Our ref: NO/2019/112110/04-L01

EXTENSION TO EXISTING WORKSHOP (B2 USE) - AMENDED/UPDATED SITE PLAN.

JAMES ALPE LIMITED LINCOLN WAY, CLITHEROE, LANCASHIRE, BB7 1QD.

Environment Agency position

PROPOSED SITE PLAN			
Site: Vehicle Repair Centre - Workshop Extension Lincoln Way Clitheroe			
Client: James Alpe			
Date: 24.09.19		Scale: 1:500/50 @ A2	
Project No: ALP/21 - Dwg 03		Drawn: AxK	
Amendments:

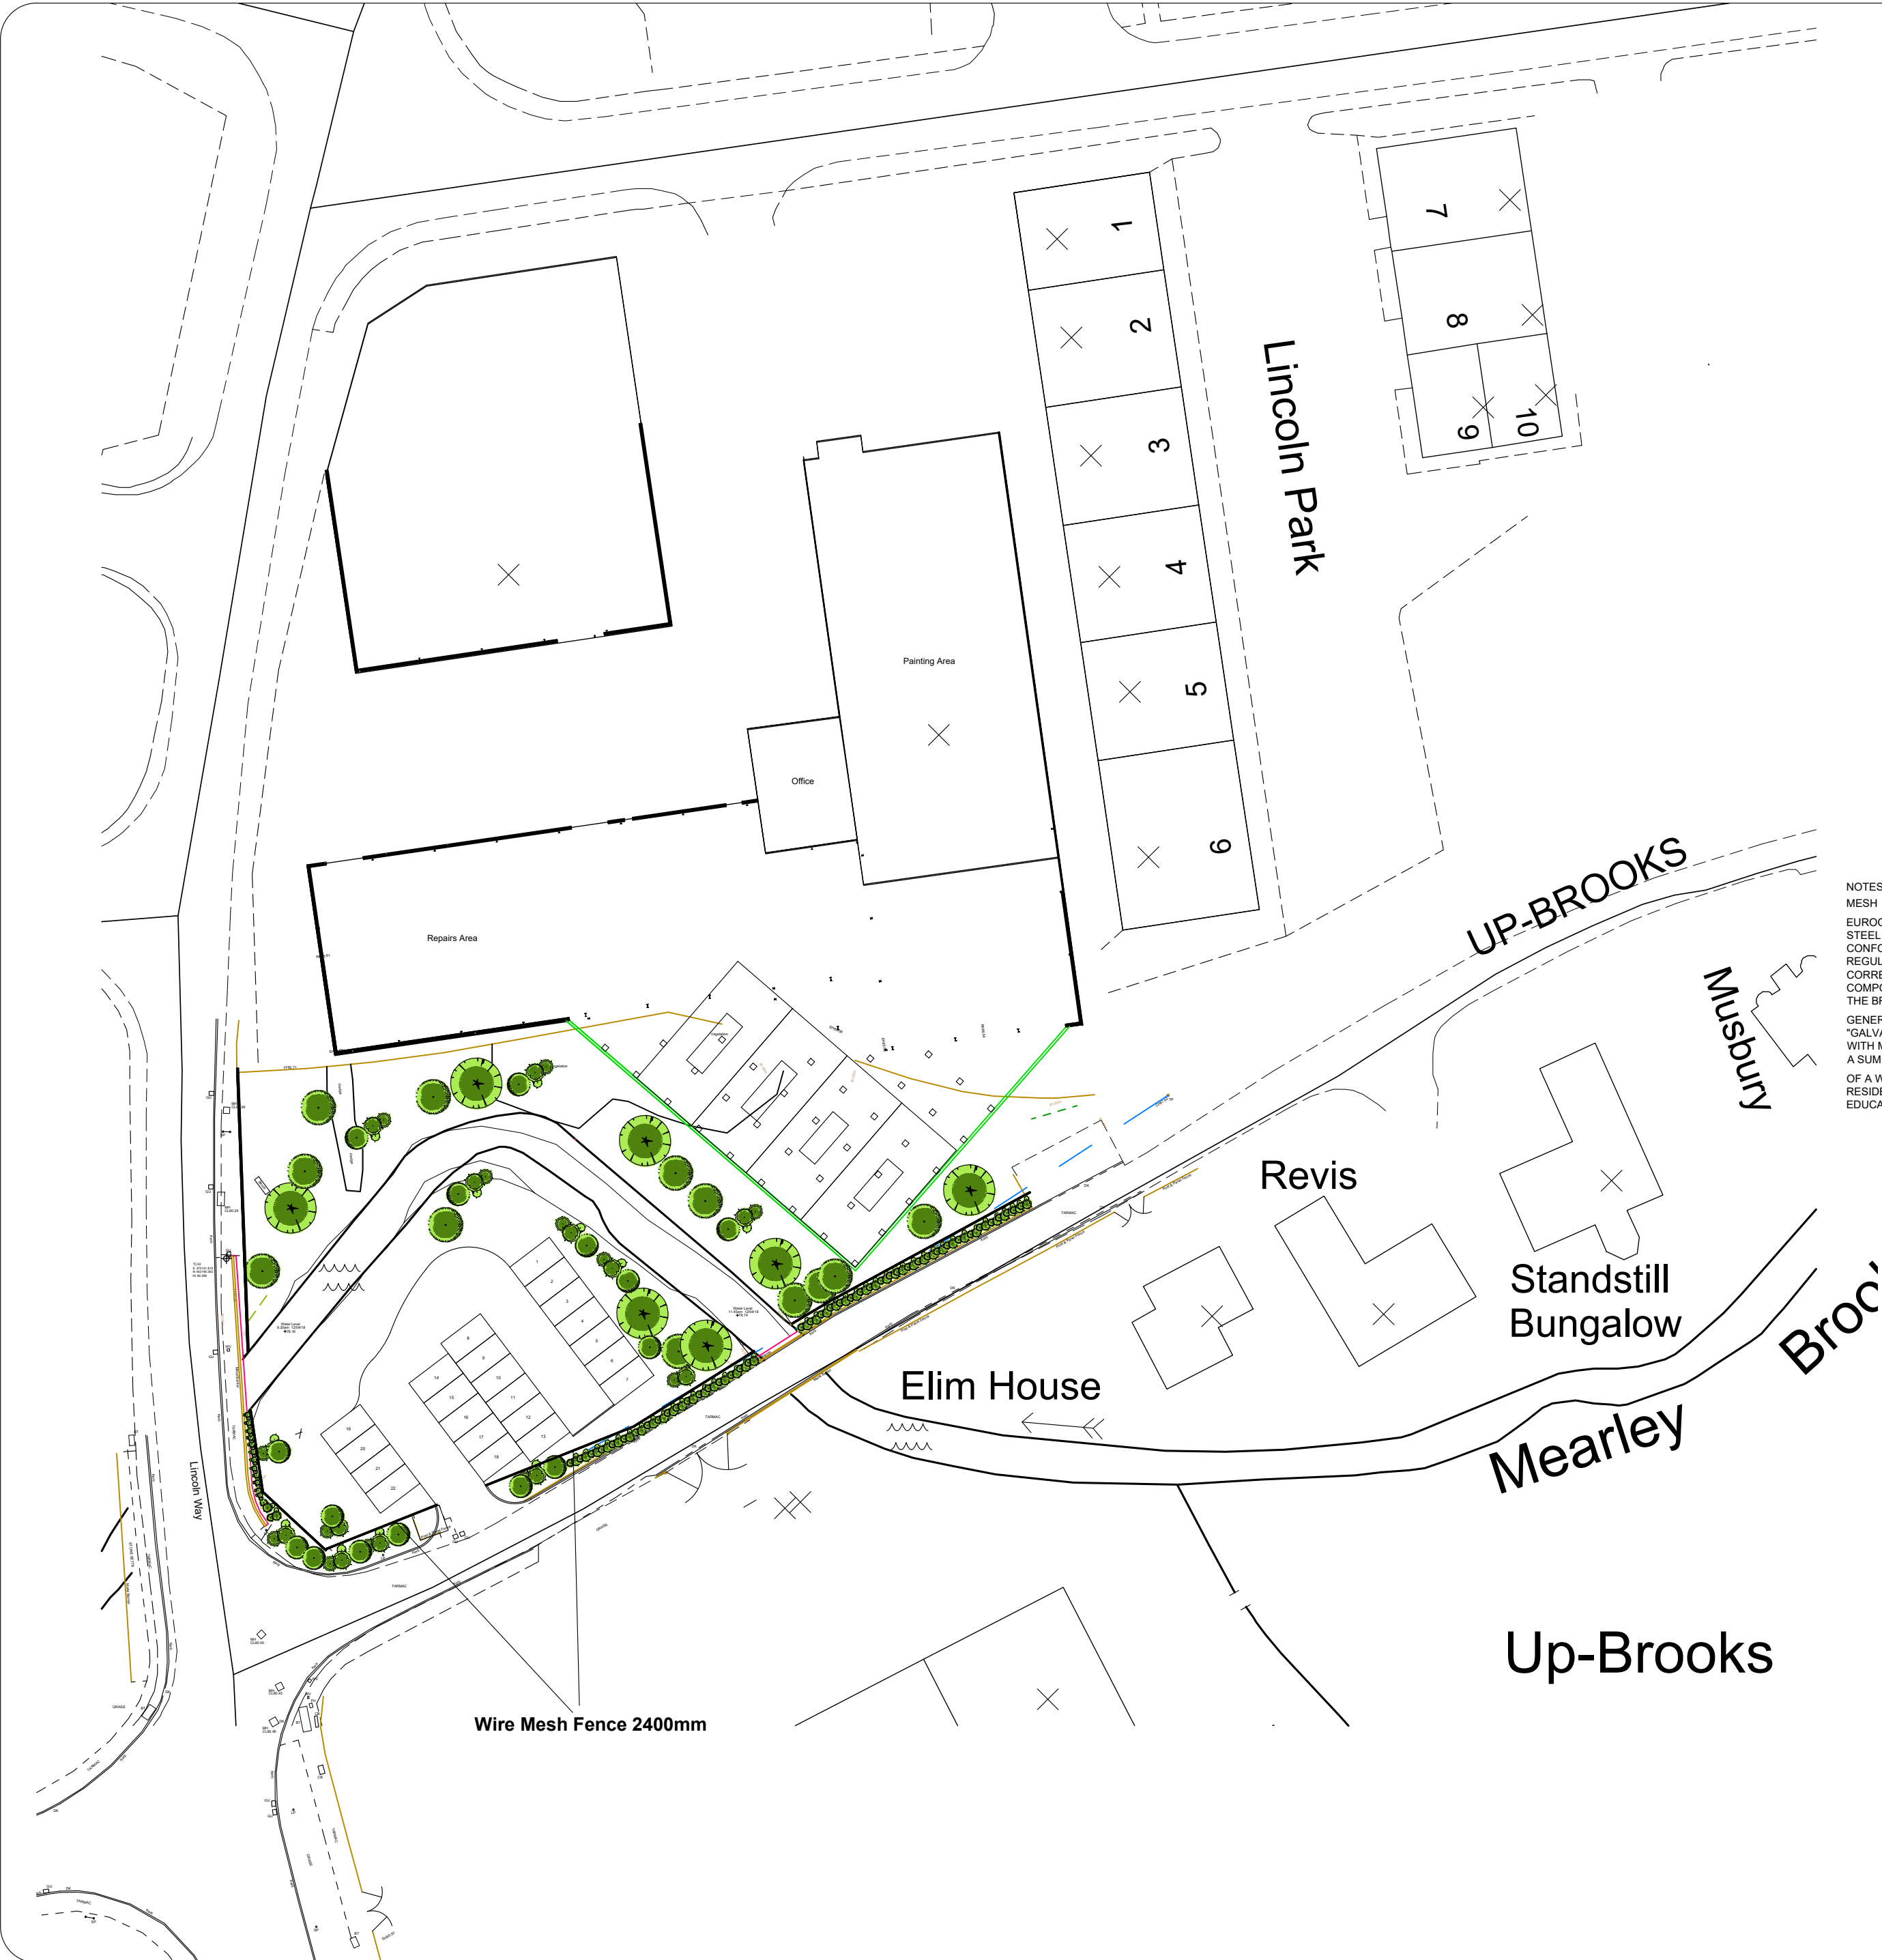
The plans for the proposal, (Project No: ALP/21 - Dwg 03c, dated 18.12.19) have been amended to remove the car-park, wire fencing and adjust the red-line boundary of the site. Unfortunately, this altered proposal for the site has not been amended within Appendix B of the FRA. We recommended that the Local Planning Authority requested that the applicant update Appendix B of the FRA on 20/03/20, however a revised FRA has not been uploaded to Ribble Valley Borough Council's planning portal.

The applicant should update Appendix B of the FRA with the plan that outlines the latest proposals for the site, as shown on the plan submitted to the LPA 06/02/20, reference; Project No: ALP/21 - Dwg 03c, dated 18.12.19.
